12455 HIGHWAY 94
OWNER: EMPRISE ACQUISITIONS LLC
PARCEL NO. 4400000056

ISSUED: 08.23.2024
LANDSCAPE PLAN
SHEET 6 OF 8

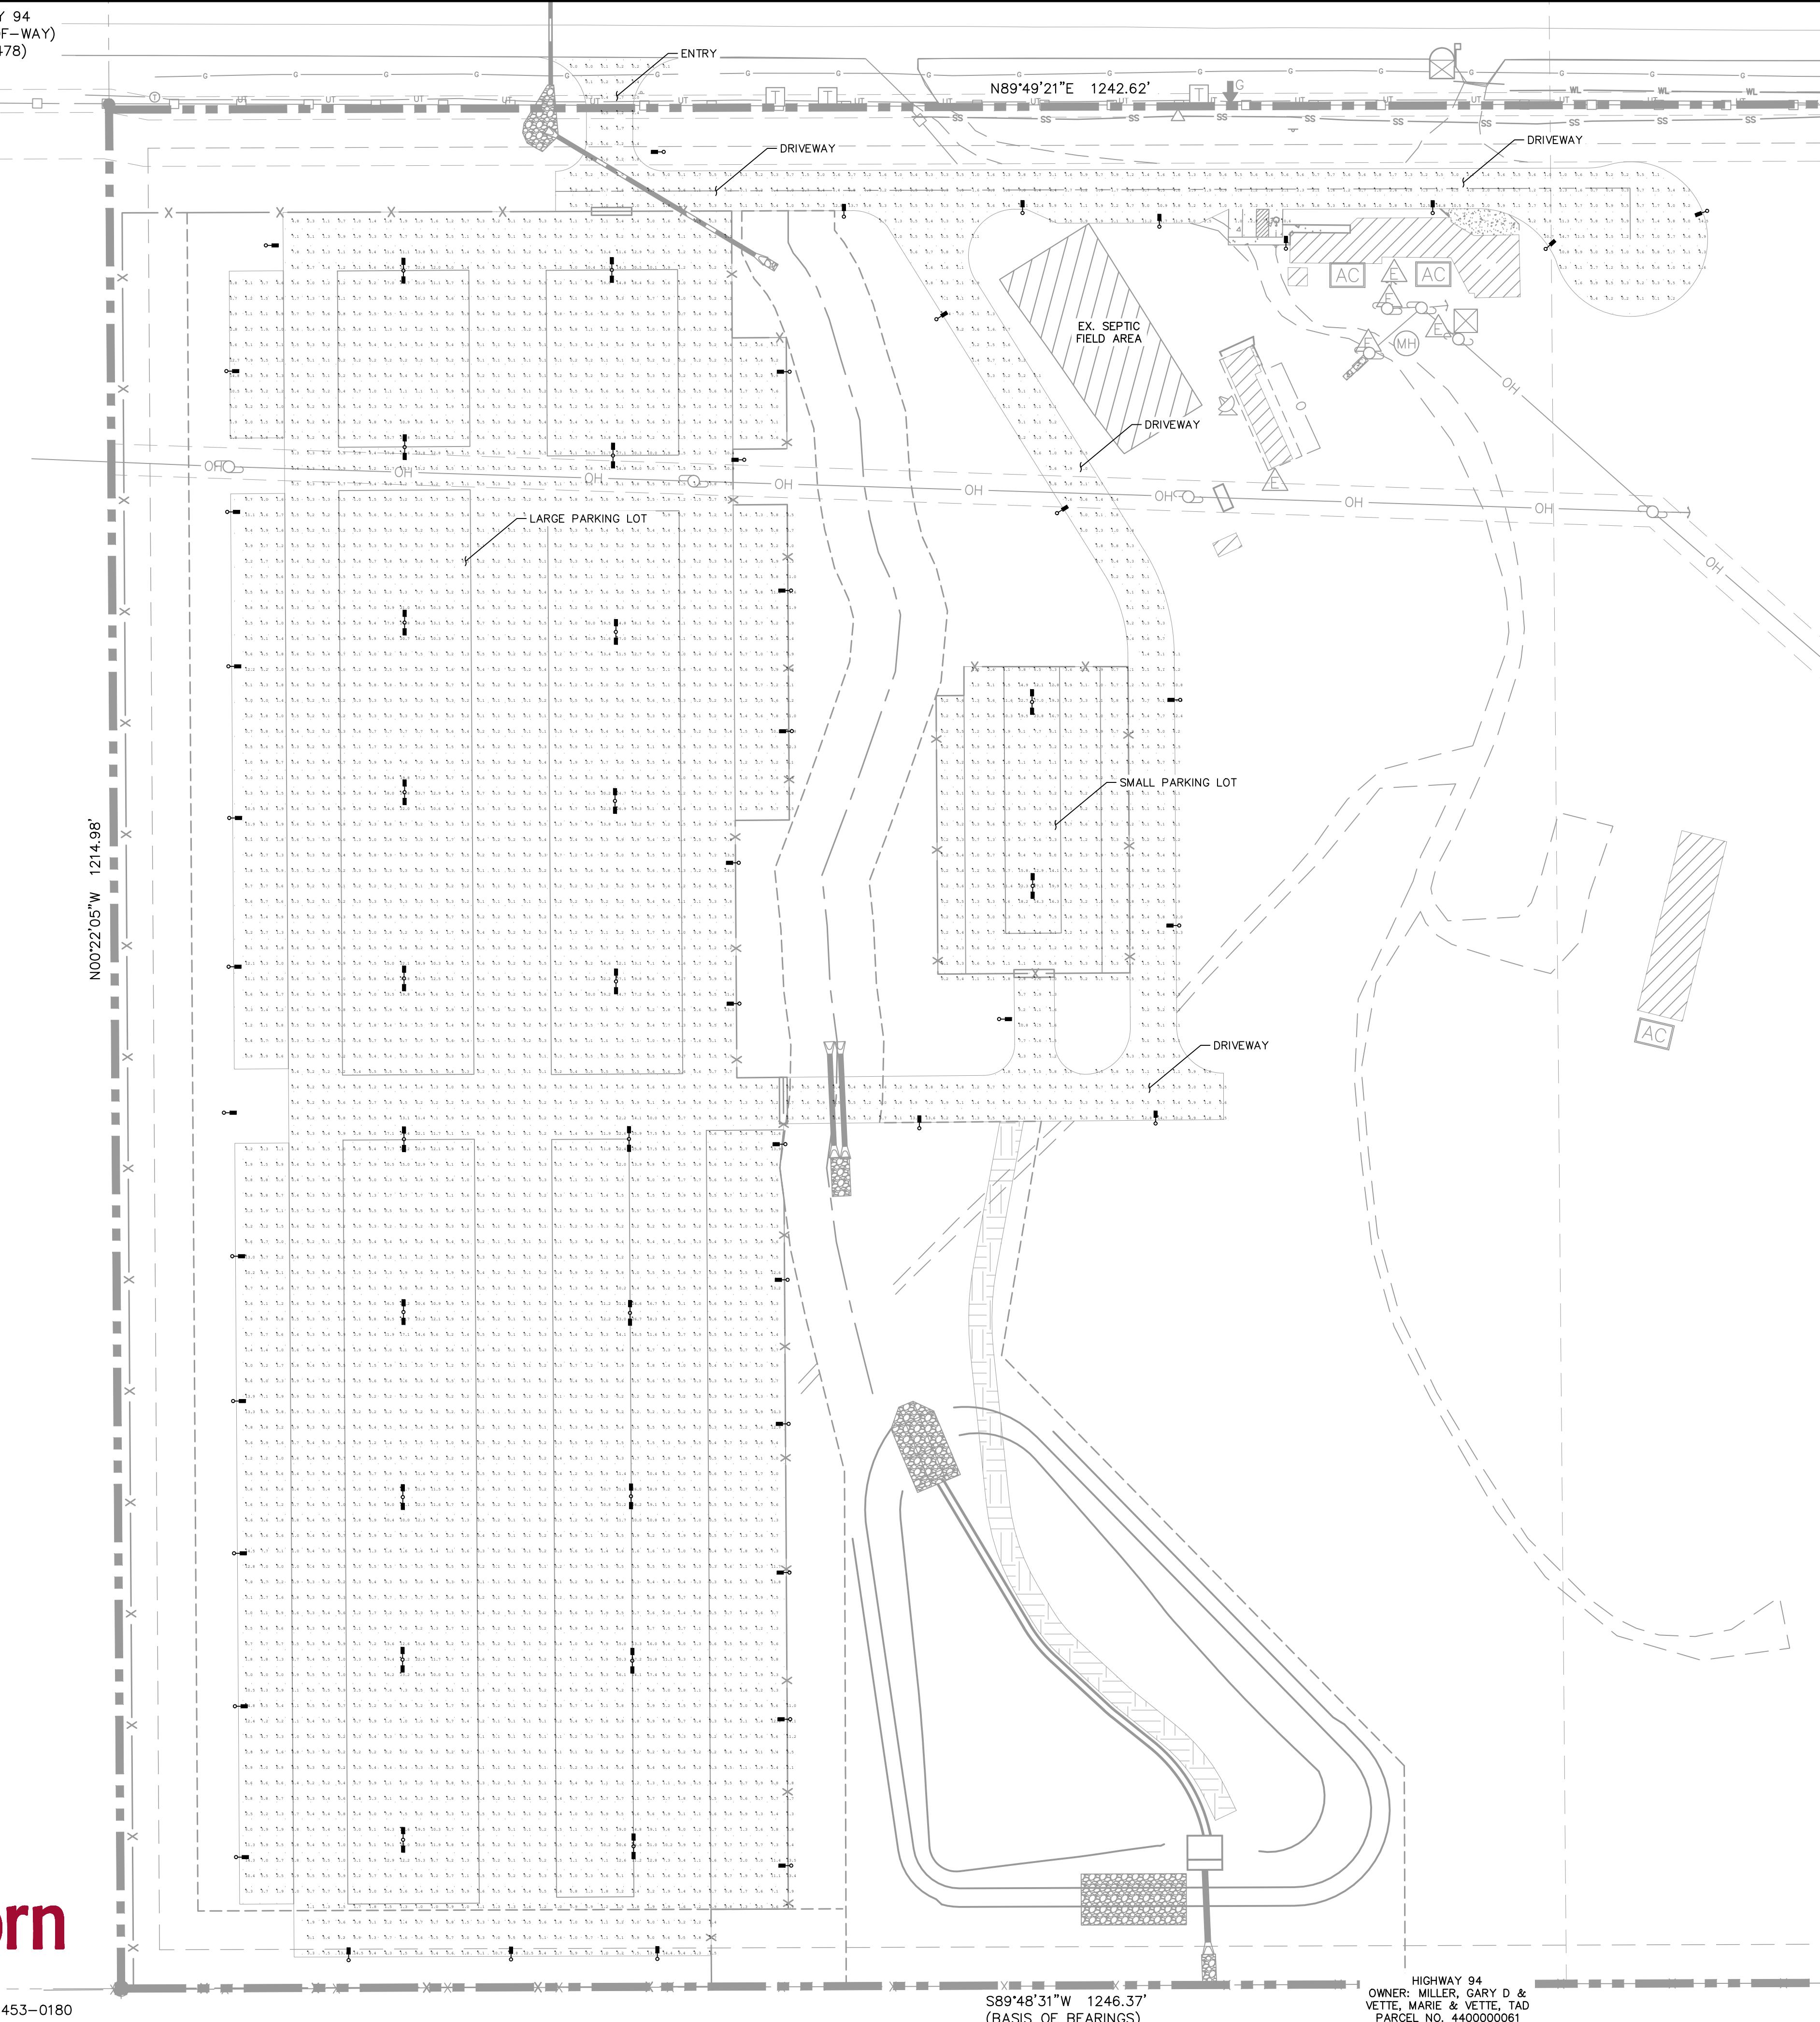
Minimum 1/3 evergreen for roadway trees.
Use at least 21 evergreens as roadway trees.

Required roadway trees = 62
Provided roadway trees = 41

Add an additional 21 trees to the 25' roadway tree area.

Per previous comments:

Landscape buffering is required between the subject lot and the residential zone district to the south.

The required buffer must extend the entire length of the lot. §6.2.2.D.2(b) requires 1 tree for every 25 feet of common parcel line. A minimum of 1/3 of the trees must be evergreen.

Per §6.2.2.D.2(c) An opaque fence or wall with a minimum height of 6 feet is required along the lot, parcel, or tract line except where the adjacent single-family or duplex residential zoning district or use abuts a required roadway landscaping area.

Per §6.2.2.D.2(d) Bark, wood chips, rock, stone, or other natural/synthetic landscape material shall be used as a non-living ground cover. Areas of a required buffer not covered in approved non-living ground cover material shall be covered in a living plant material

The west property line also abuts a residential zone district. A buffer is required there as well.

The required buffer must extend the entire length of the lot. §6.2.2.D.2(b) requires 1 tree for every 25 feet of common parcel line. A minimum of 1/3 of the trees must be evergreen.
